Ricardo
Energy & Environment

Manston Airport DCO Application: Review of noise documentation following noise hearing

Report for Thanet District Council, 2nd May 2019

Figure 12.7
Aircraft noise - night-time $L_{Aeq,8hr}$
contours - year of forecast maximum
capacity

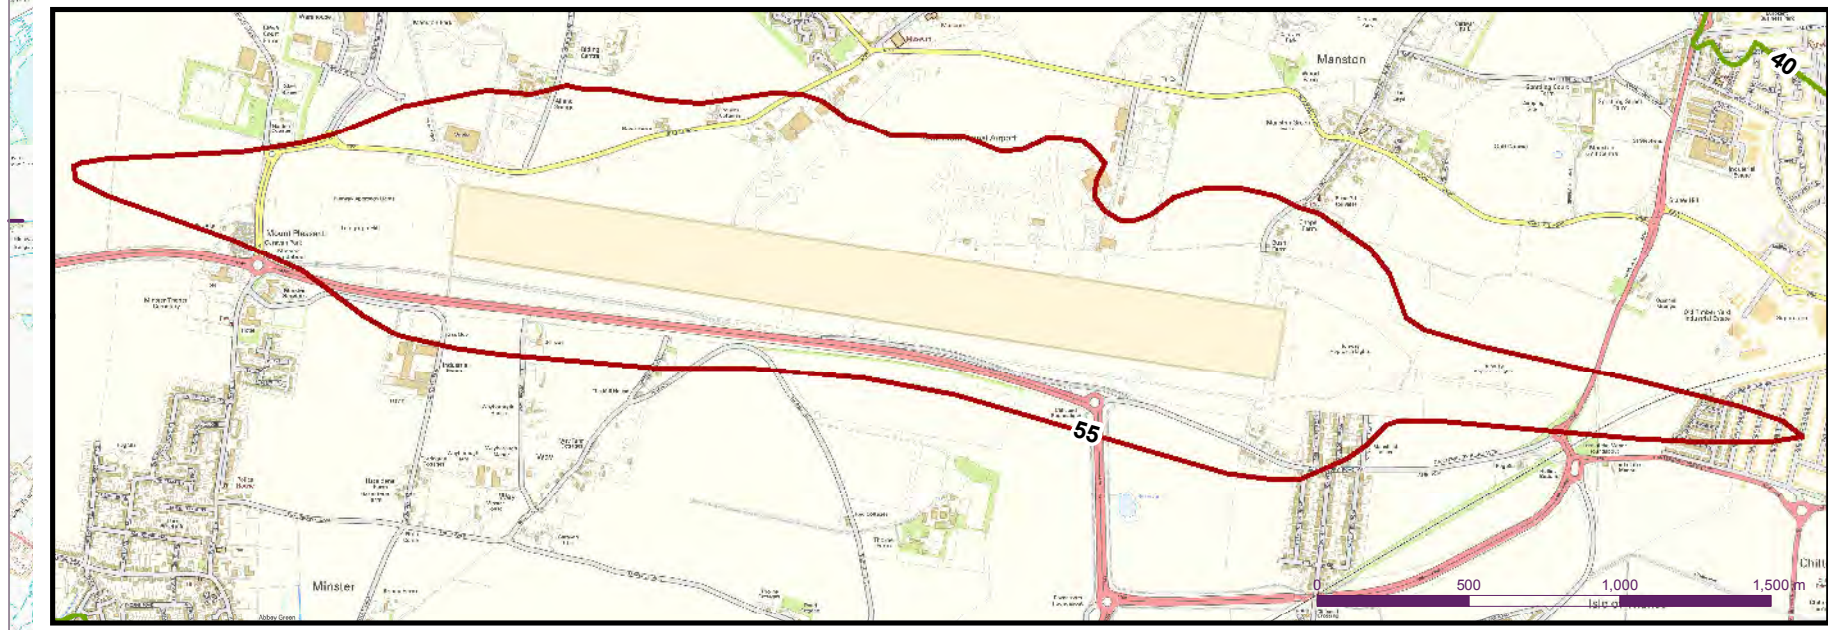
<p>5. combined aircraft and traffic LAeq 16 hour and 8 hour contours if the traffic noise component exceeds screening</p>	<p>We are not aware of any previous Environmental Impact Assessment (EIA) noise assessment where significant effects are determined using combined aircraft and road traffic noise contours.</p> <p>It is widely accepted that people respond differently to noise from different sources. This is illustrated by the evidence presented in the most recent World Health Organisation (WHO) guidance on noise (Environmental Noise Guidelines for the European Region, WHO 2018) which sets out separate source specific guideline values and noise dose-response</p>	<p>The Applicant is unaware of any EIA where significant effects are determined using combined aircraft, and road traffic noise contours. The Applicant further states that the separate source specific guideline values and noise dose-response relations for road and aircraft noise are described in the WHO Guidelines for the European Region 2018. The Applicant further considers that no guidance is provided for assessing the combined effects of exposure to multiple sources. The Applicant considers that conventionally noise from separate sources for airport applications is dealt with separately and is considered not feasible to derive a “cumulative noise impact”.</p>	<p>Request consideration of the cumulative impact of combined development noise levels at receptors through combined predictions and contour maps.</p>

Request	Applicant response	Assessment of applicant response	Recommendation
	<p>relationships for Road, Rail and Aircraft noise. No guidance is provided for assessing the combined effects of exposure to multiple sources of noise. Whilst total noise from multiple sources can be determined, there is no reliable dose-response data to show what the effect of these combined sources of noise is on people. Therefore, it is more appropriate to consider the noise sources separately and determine the overall effect.</p> <p>We are therefore confident that the approach taken in the Environmental Statement (ES) is robust and any revised transport modelling that may be undertaken to confirm significant impacts should adopt a receptor-based approach, rather than a noise contour approach.</p>	<p>ProPG (Professional Practice Guidance on Planning & Noise) provides guidance on the assessment of cumulative noise from transport sources on new residential development. ProPG uses the combined free-field noise level from all transport sources and also commercial noise where the character of the commercial noise is not dominant to provide an initial risk of noise at proposed development sites. The area within the 50 dB $L_{Aeq,8hr}$ contour, which can be found in the Ecology Chapter of the ES (shown in Figure 2.1 included below) and above would be classified as “Medium Risk” and an Acoustic Design Statement would be required to demonstrate how the adverse impacts of noise would be mitigated and minimised and also be required to clearly demonstrate that a significant adverse noise impact is avoided.</p> <p>The IEMA Guidelines for Environmental Noise Impact Assessment recommend that the change in noise levels as well as the absolute noise levels are considered. At present the noise assessments do not consider the total noise level or the total change in noise levels and so the ‘with development’ and the ‘without development’ scenarios are difficult to fully consider.</p> <p>It is noted that without the consideration of the cumulative sources noise of air noise, ground noise, traffic noise and plant noise the predicted significance of the effect may be understated.</p> <p>It is understood the noise assessments of the for the Heathrow expansion DCO are using combined noise impact contours.</p> <p>Note: See Figure 2.1 beneath this Table 2.1.</p>
